CCES
Responses

FLYING HORSE NORTH FILING NO. 1
GRADING AND EROSION CONTROL PLAN

FLYING HORSE NORTH FILING NO. 1
COUNTY OF EL PASO, STATE OF COLORADO
GRADING AND EROSION CONTROL PLAN
DECEMBER 2017

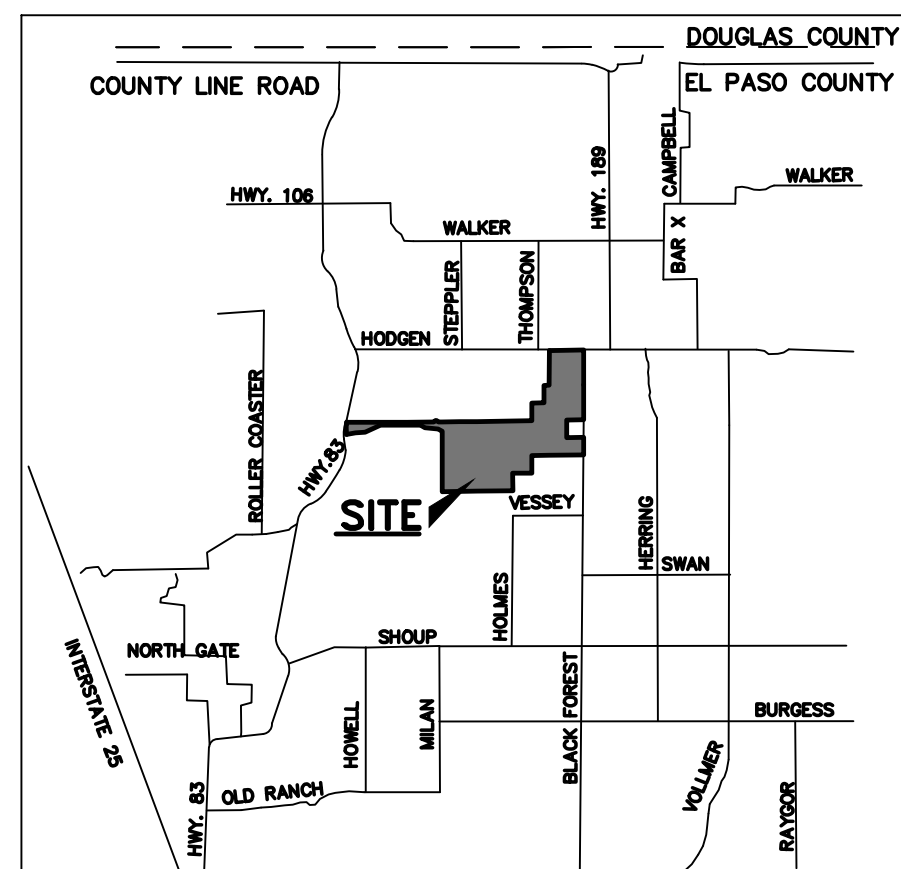
Fill in the blank

Add PCD File No. SF-18-001

Resolved
05/30/2018

FLYING HORSE NORTH FILING NO. 1
GRADING AND EROSION CONTROL PLAN

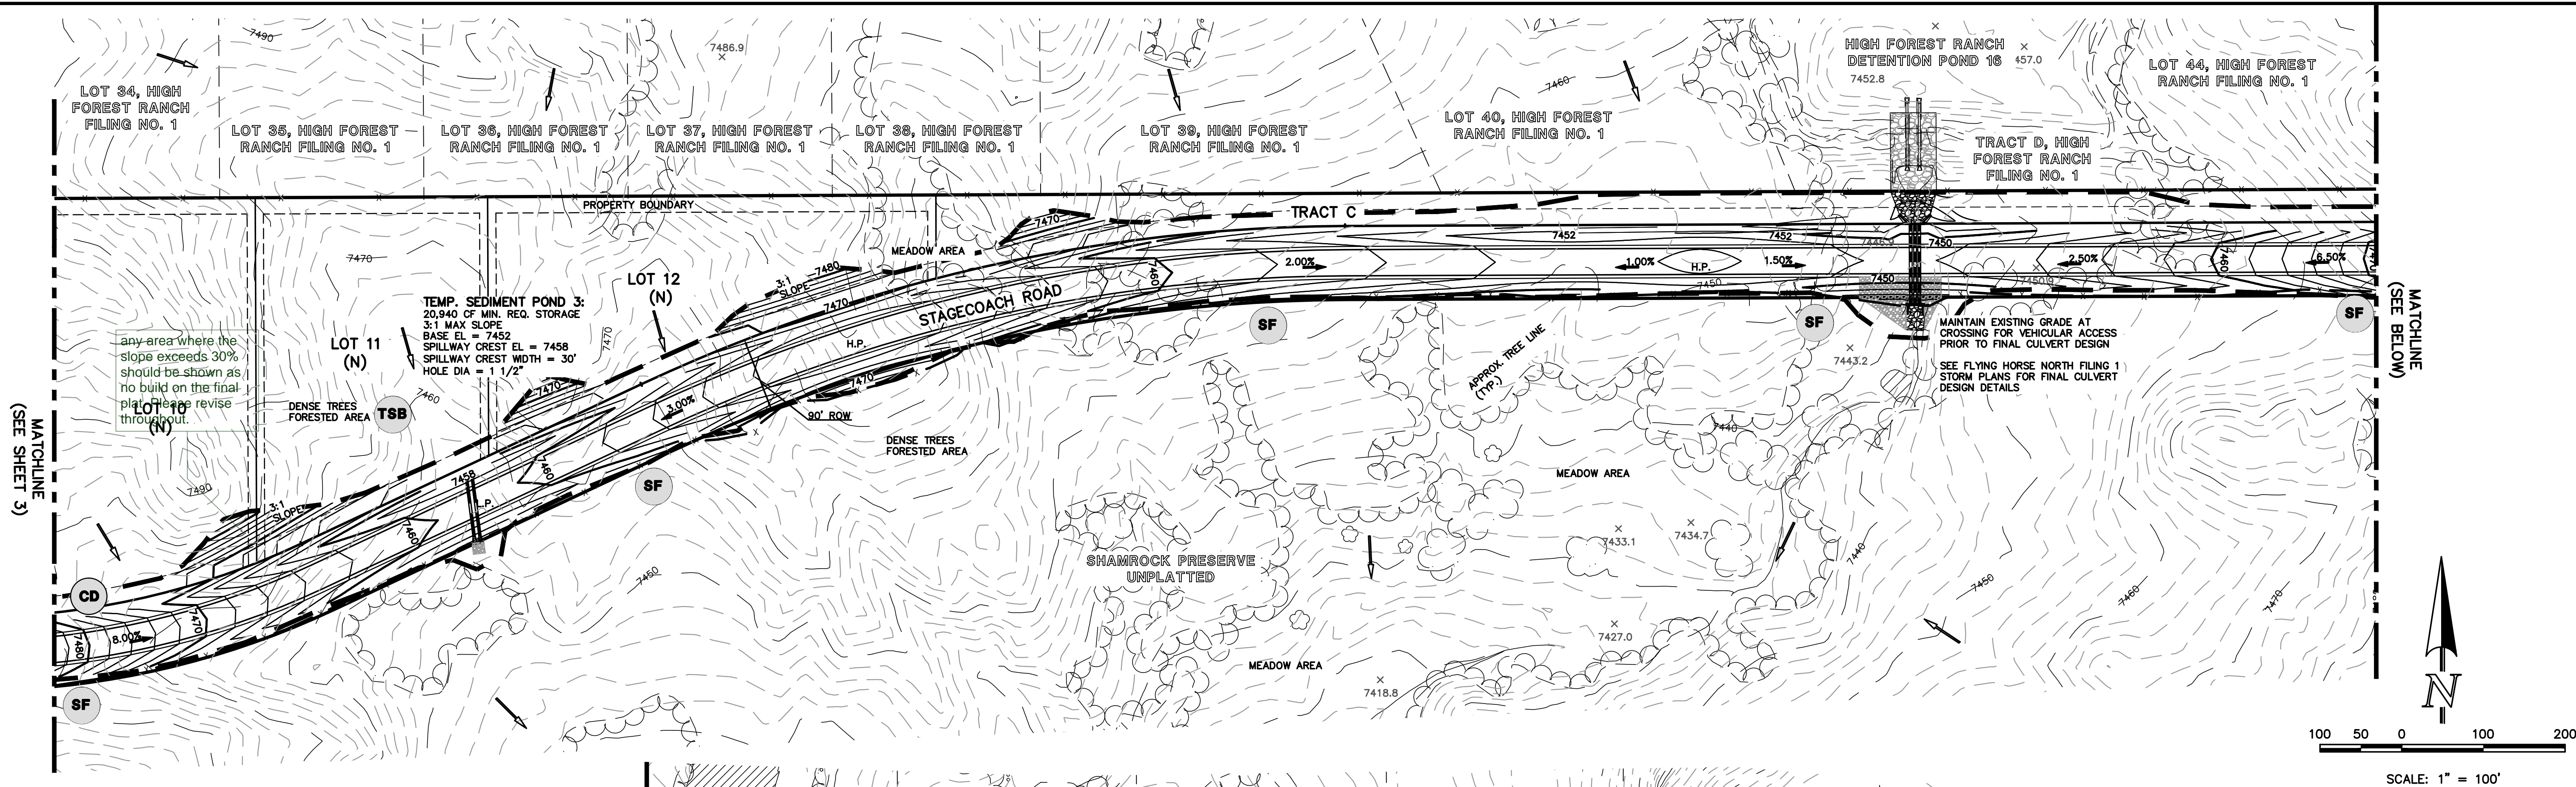
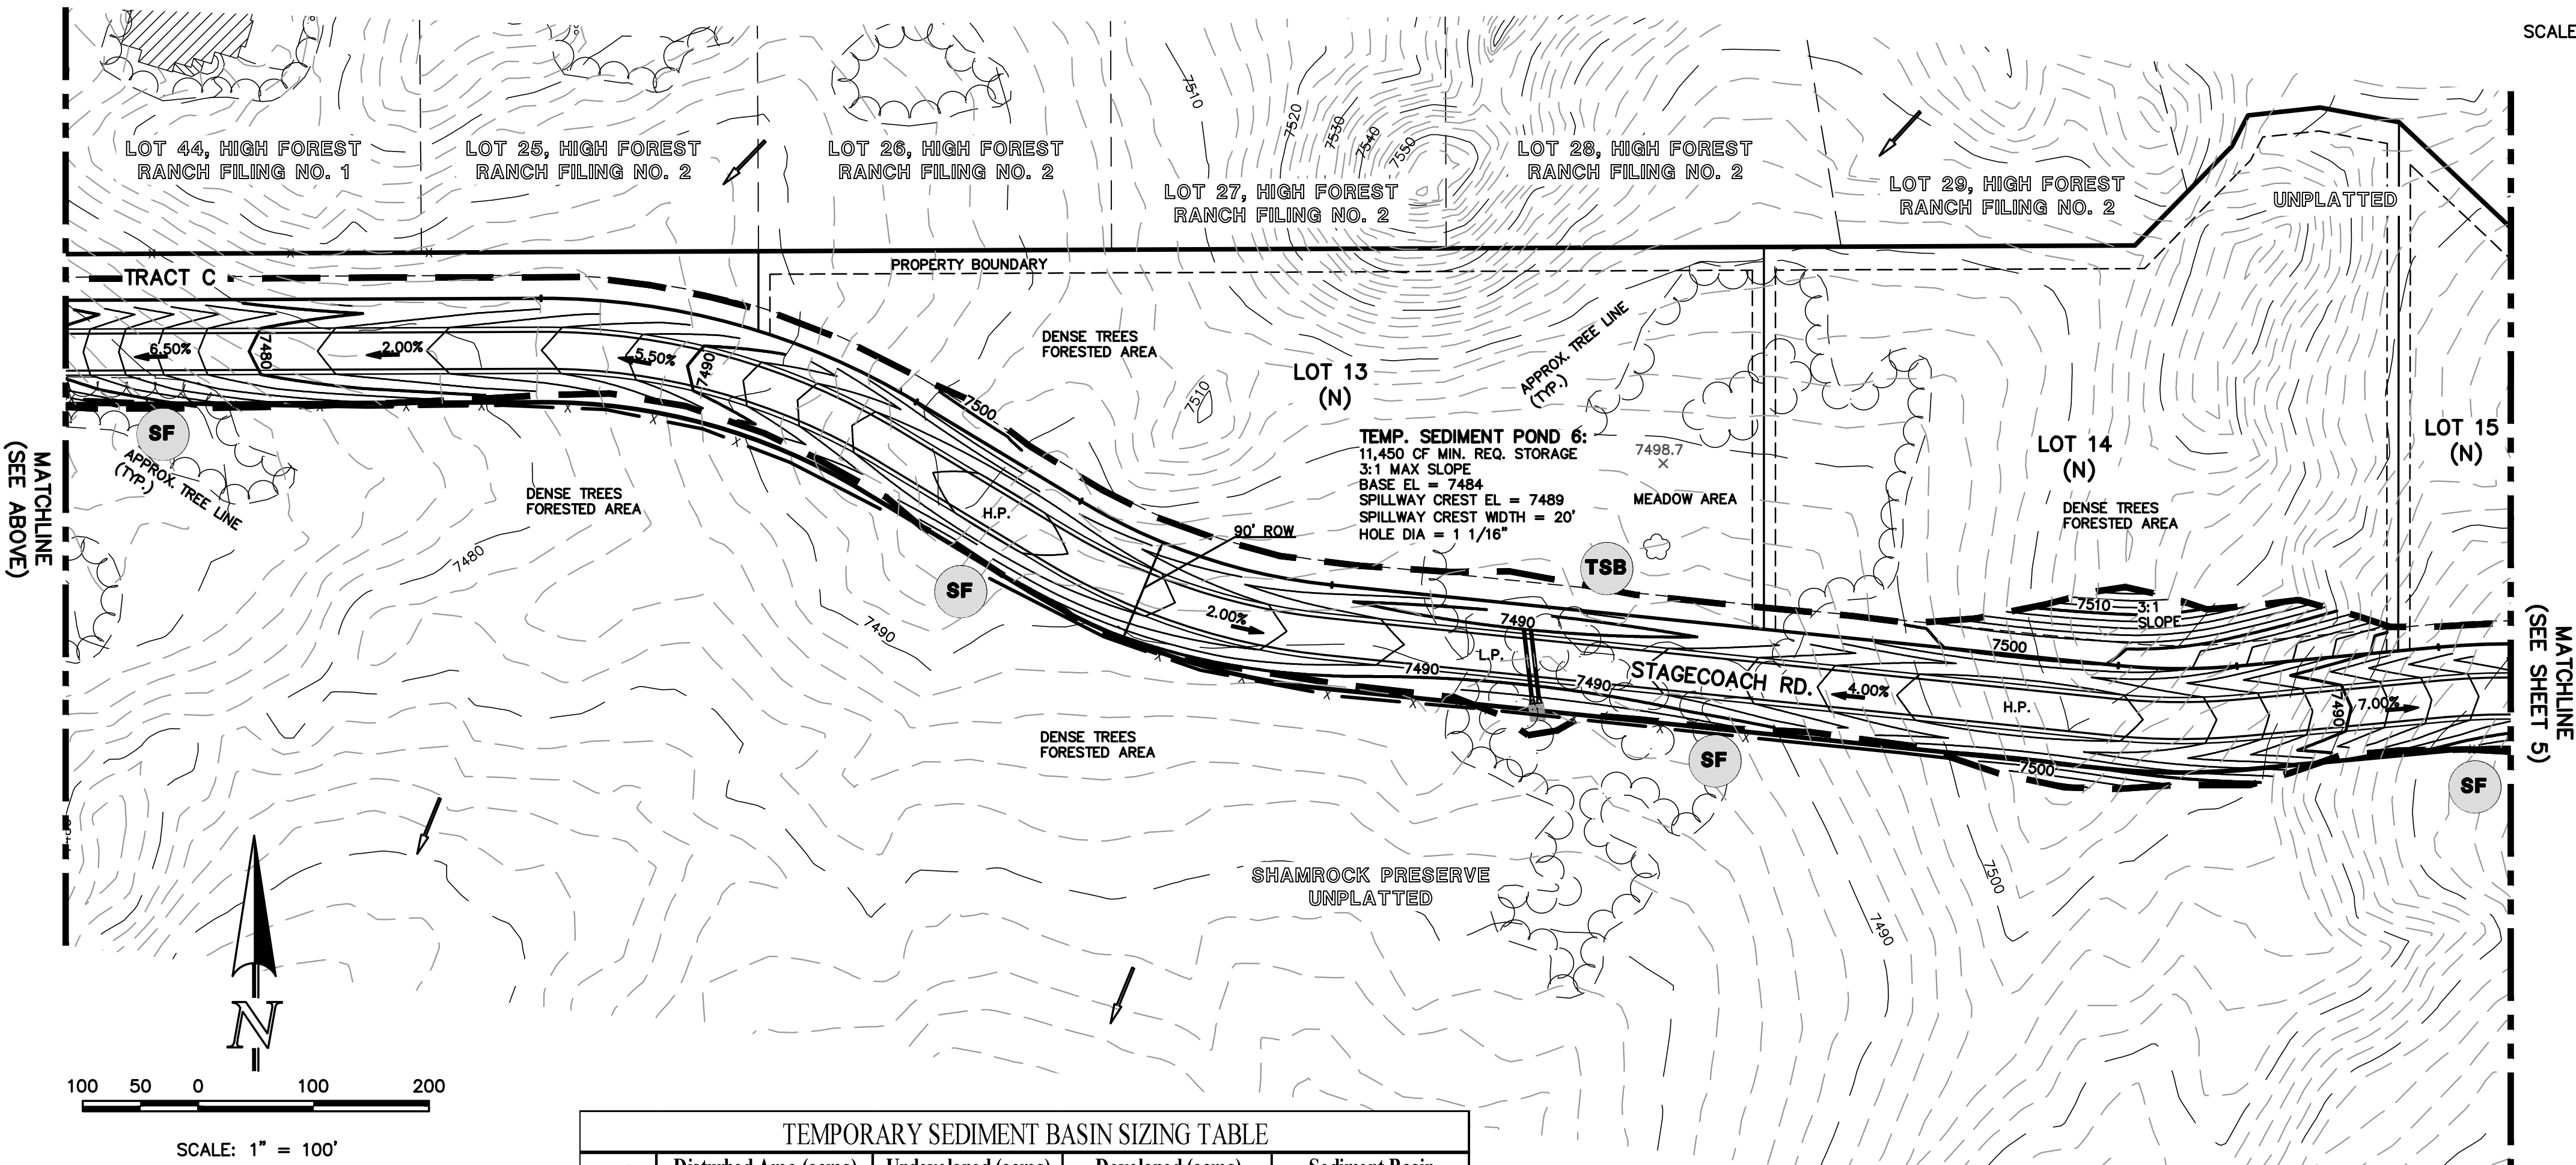
A geotechnical analysis and report with recommendations for the foundation preparation and embankment construction shall be submitted with the complete design analysis for all permanent detention facilities.

Per DCM Chapter 11 Section 11.3.3 a geotechnical analysis and report with recommendations for the foundation preparation and embankment construction shall be submitted to the County with the complete design analysis for all permanent detention facilities.
This may be submitted as a supplementary report from the existing soils report for Flying Horse North.

Entech providing separate report for ponds

Resolved
05/30/2018
